**REQUEST**

Current Zoning: N1-A (neighborhood 1-A)  
Proposed Zoning: R-12MF(CD) (multi-family residential, conditional)

Approximately 19.91 acres located on the east side of North Tryon Street, east of Pavilion Boulevard.

The petition proposes a residential community containing a maximum of 200 multi-family dwelling units and, any incidental and accessory uses permitted in the R-12MF zoning district.

**SCHEMATIC
 SITE PLAN**

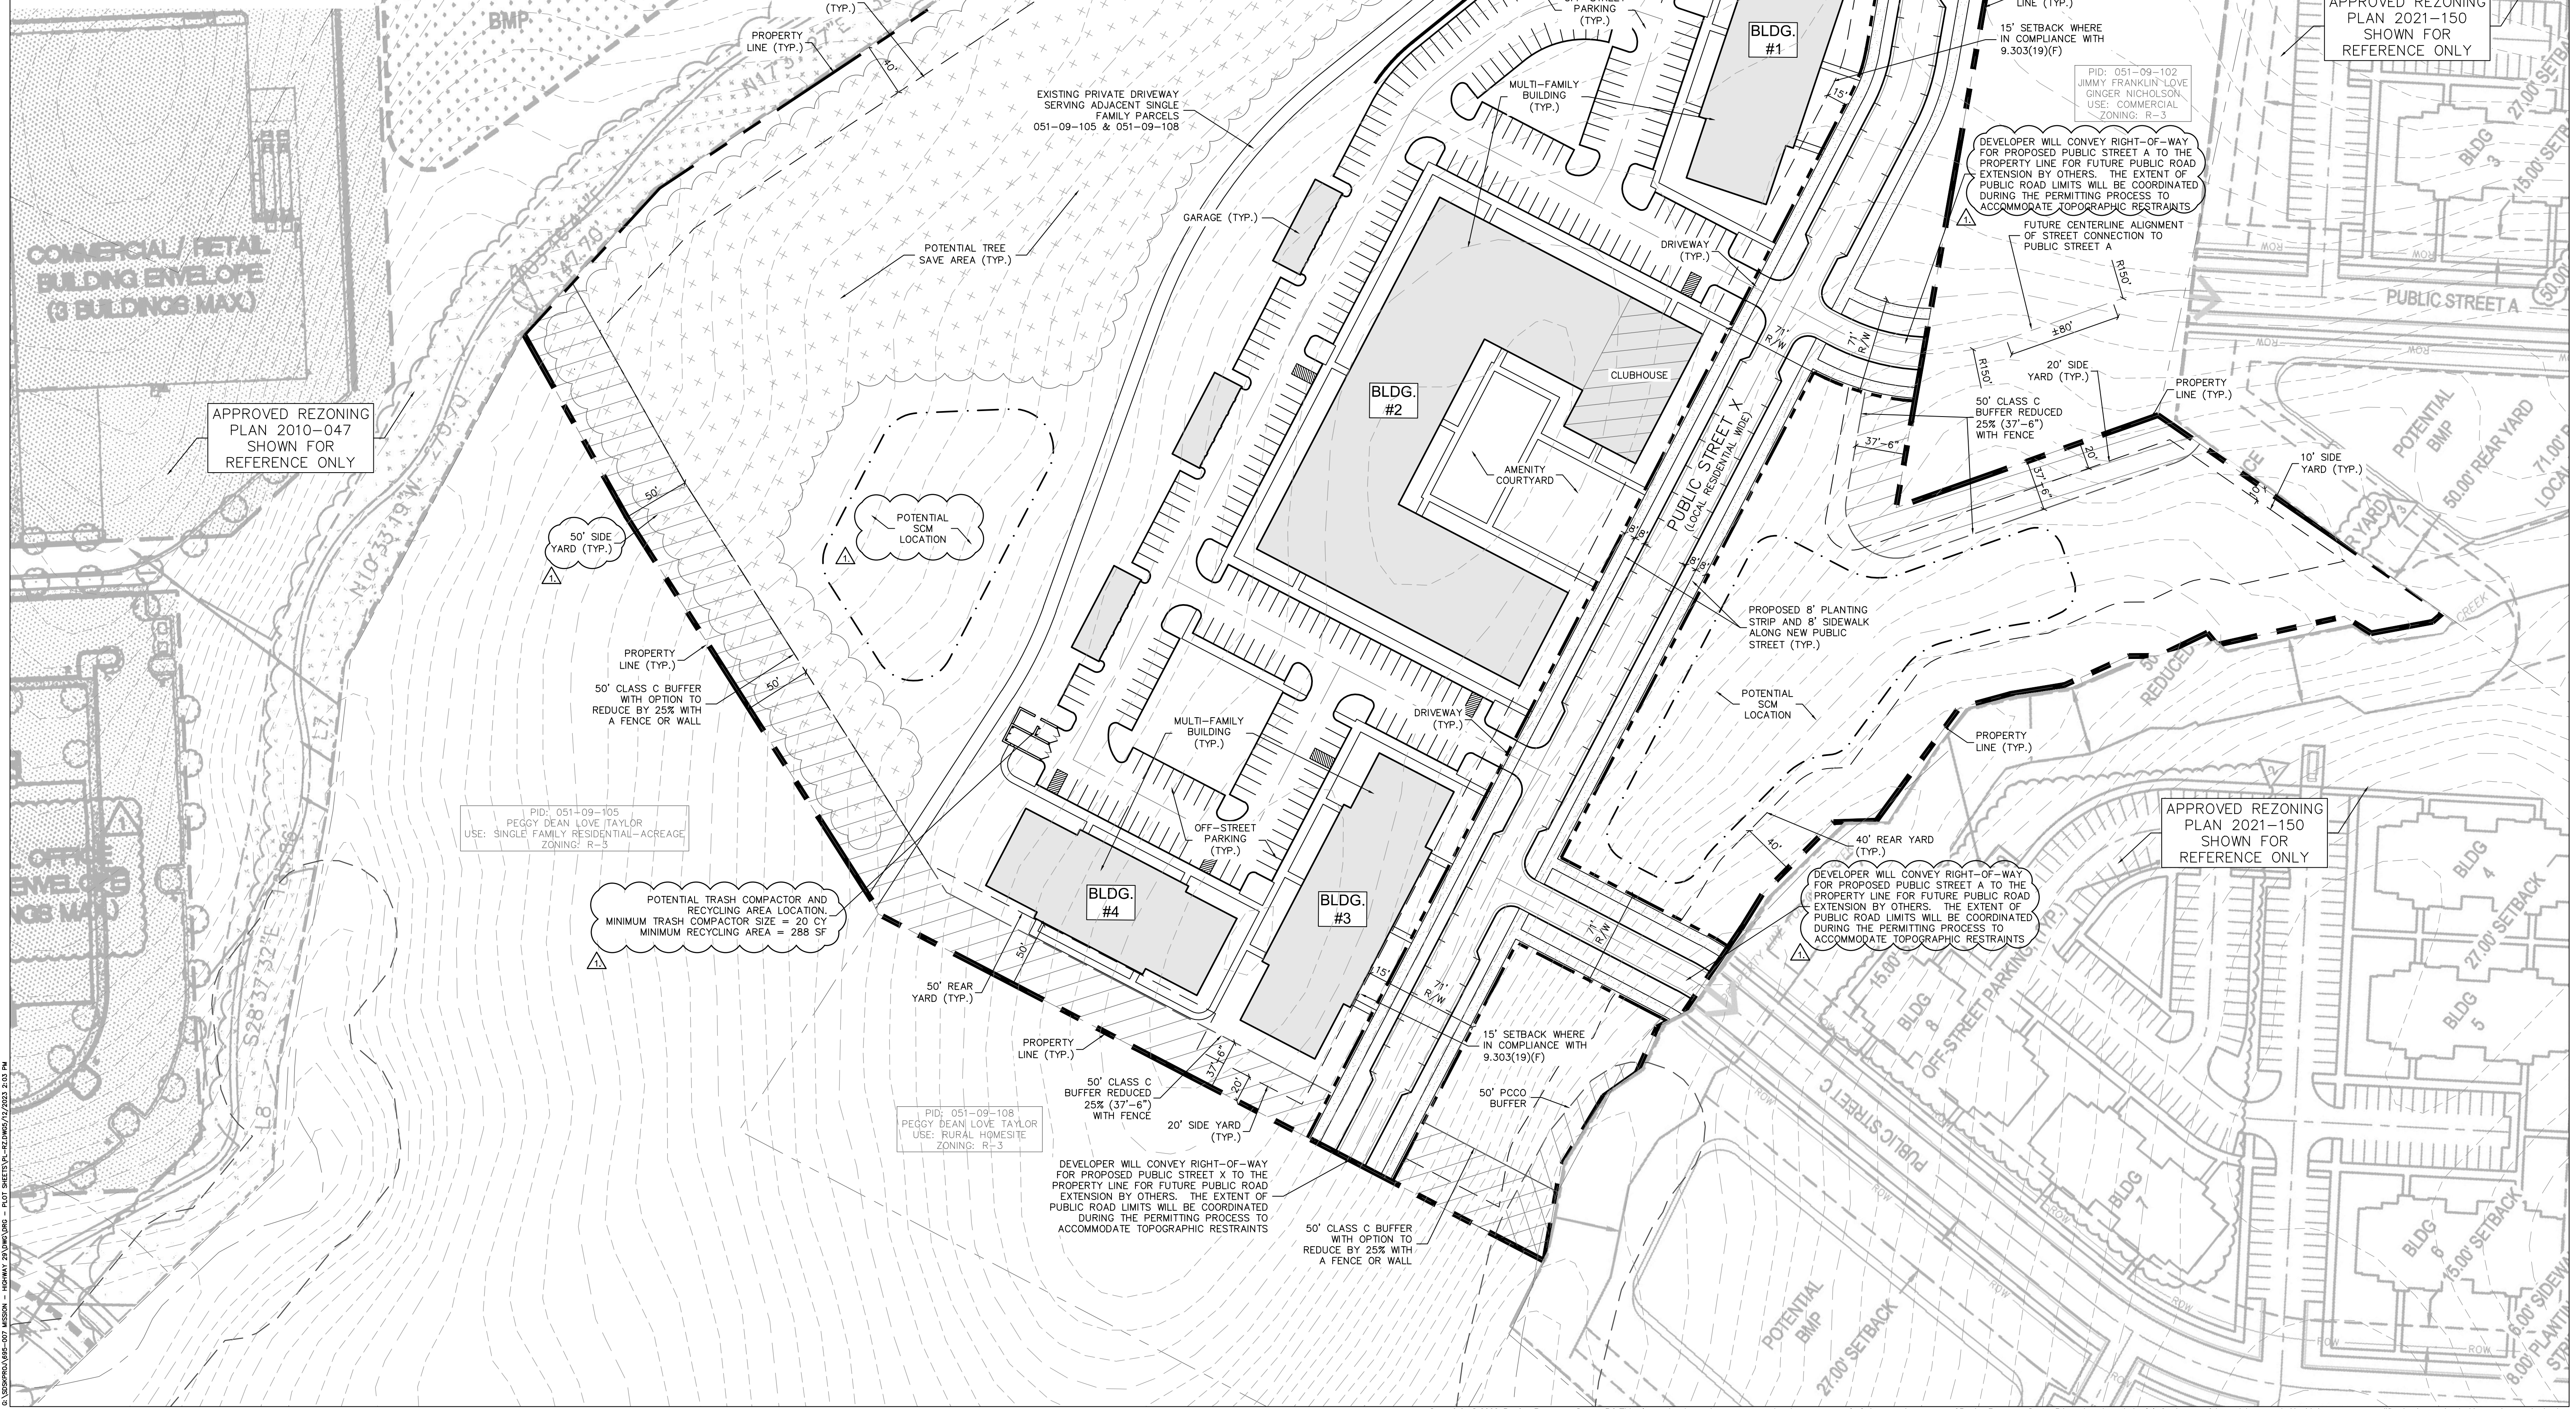
- The site is adjacent to US Highway 29, a State-maintained major throughfare, and north of Wrayhill Drive, a City-maintained local street. A Traffic Impact Study (TIS) is not required for this site due to the site generating less than 2500 daily trips. Conditional note revisions are needed to commit to completing transportation improvements prior to the first certificate of occupancy for the site. Further details are listed below.

1. Add a conditional note specifying "All transportation improvements will be approved and constructed before the site's first building certificate of occupancy is issued. The petitioner may phase transportation improvements if said improvements and phasing are explicitly described in site plan notes."
